**re:** **Geotechnical Response to City Comments**  
**Proposed Self Storage Development**  
**75 Michael Cowpland Drive – Ottawa, Ontario**

**date:** November 21, 2023

**file:** PG3798-MEMO.04

SHEET TITLE
CROSS SECTIONS

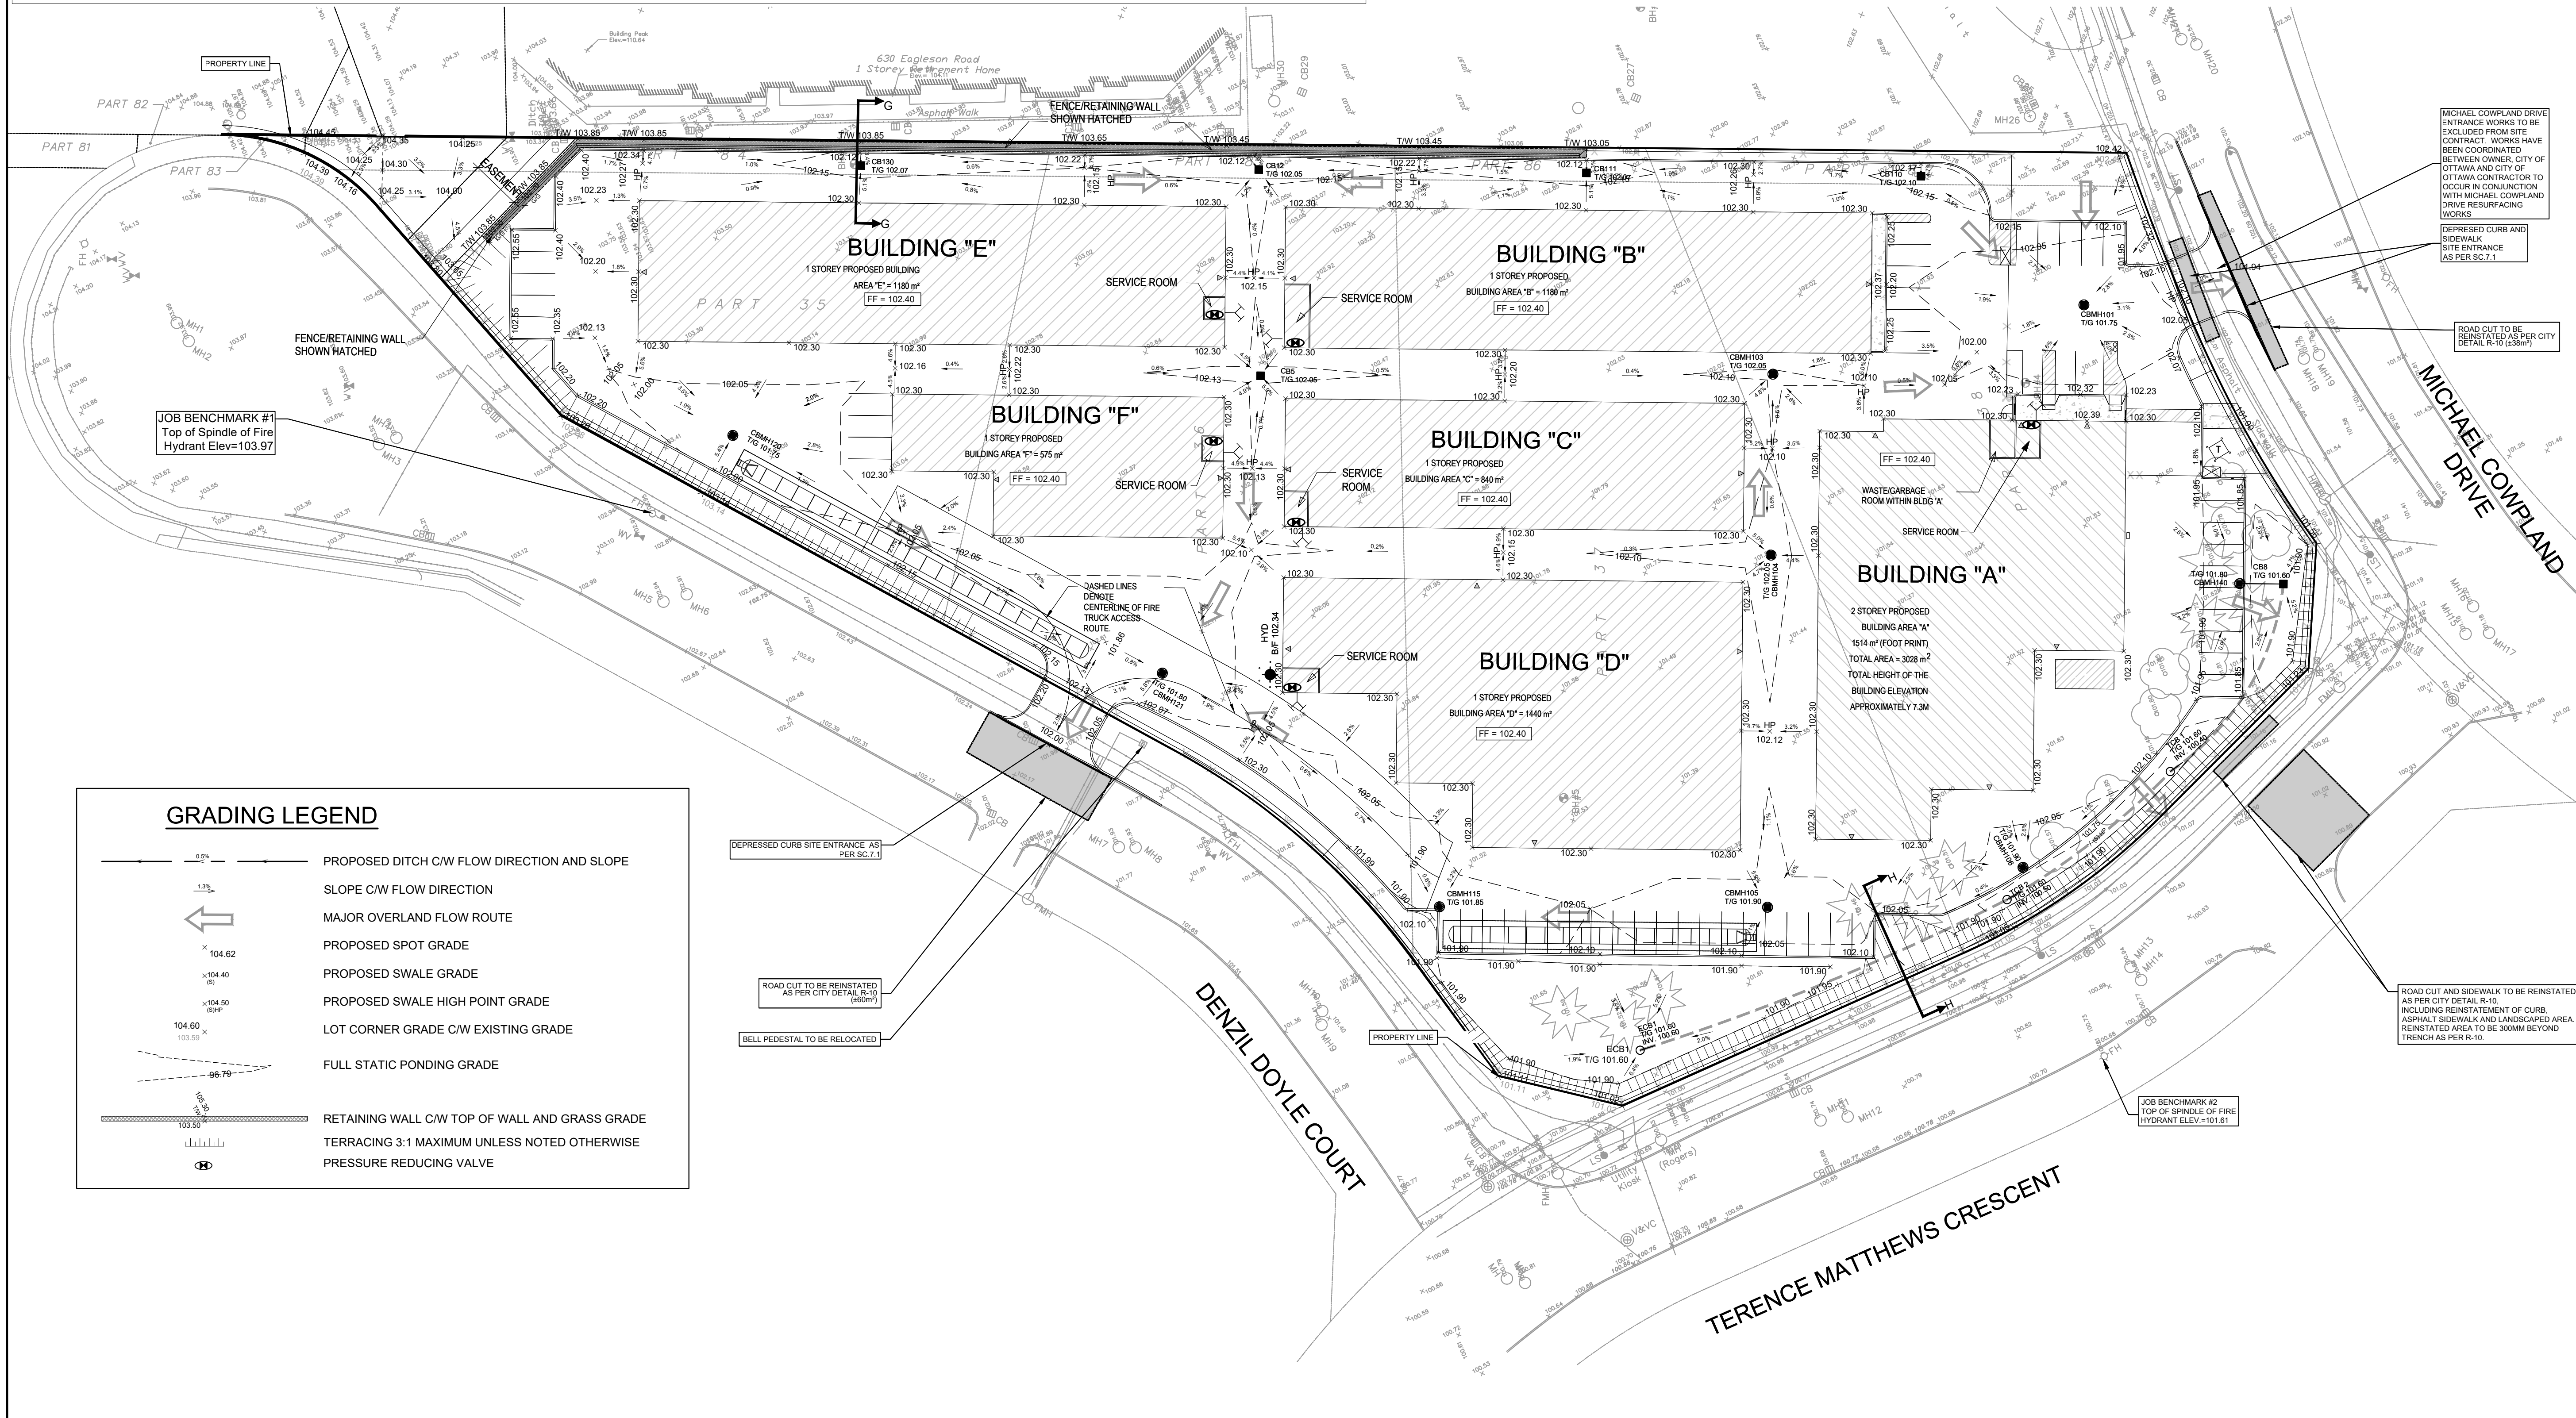
**New Comment 1.50:** *The cross-sections have not been updated.*

**Paterson Response:** Based on our review of Drawing C-011, Cross Sections, Revision 6 dated November 13, 2023, prepared by Arcadis, the long-term pre-development groundwater table provided in Paterson Group memorandum PG3798-MEMO.03 dated September 5, 2023, has been provided on the pertinent cross-sections. Based on this, this comment has been responded to in accordance with our recommendations by Arcadis.
